Subject: FW: Planning Consultation on: CM/4/22/DOC

Engineers Comments Regarding Condition 8

Application No: CM/4/22/DOC

Description of Works: Approval of details reserved by condition imposed under ref CM/64/19/PL relating to Condition Nos 8 - as-built drawings and 14 - energy efficiency.

As-built Survey

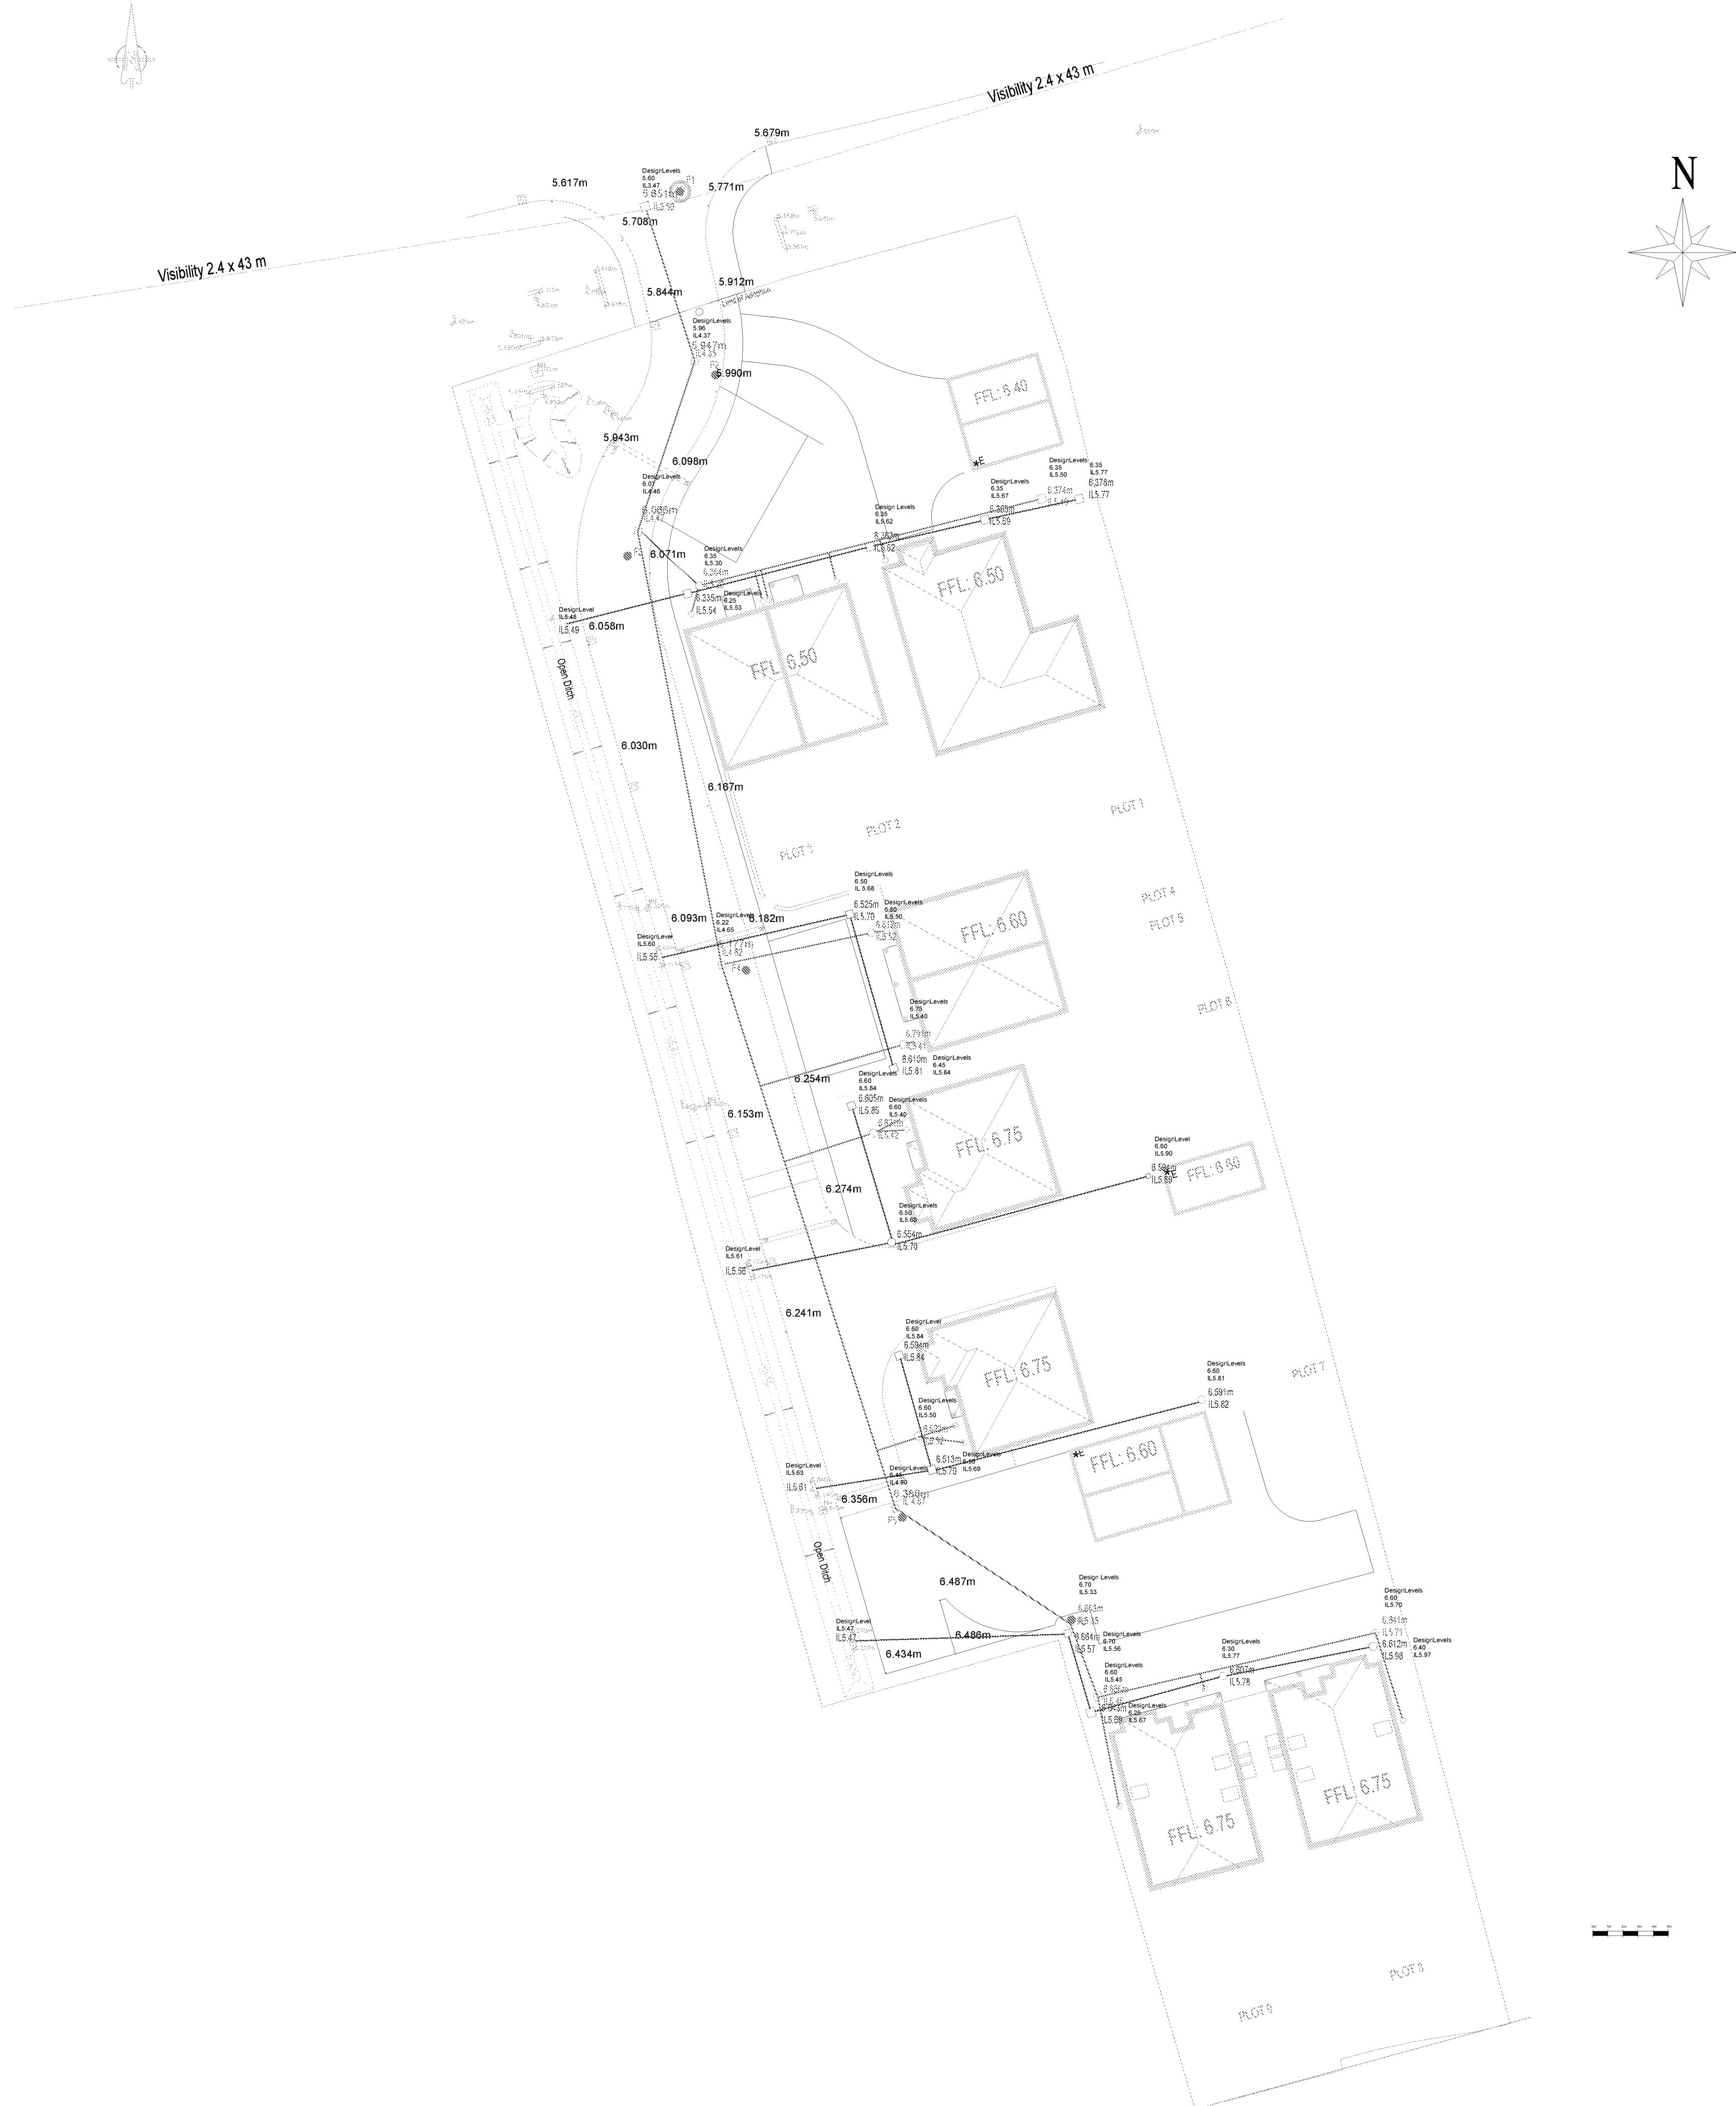
Please provide details of the inspection and verification of control chambers. I.e. surveyed invert and cover levels and good receipts for flow control devices.
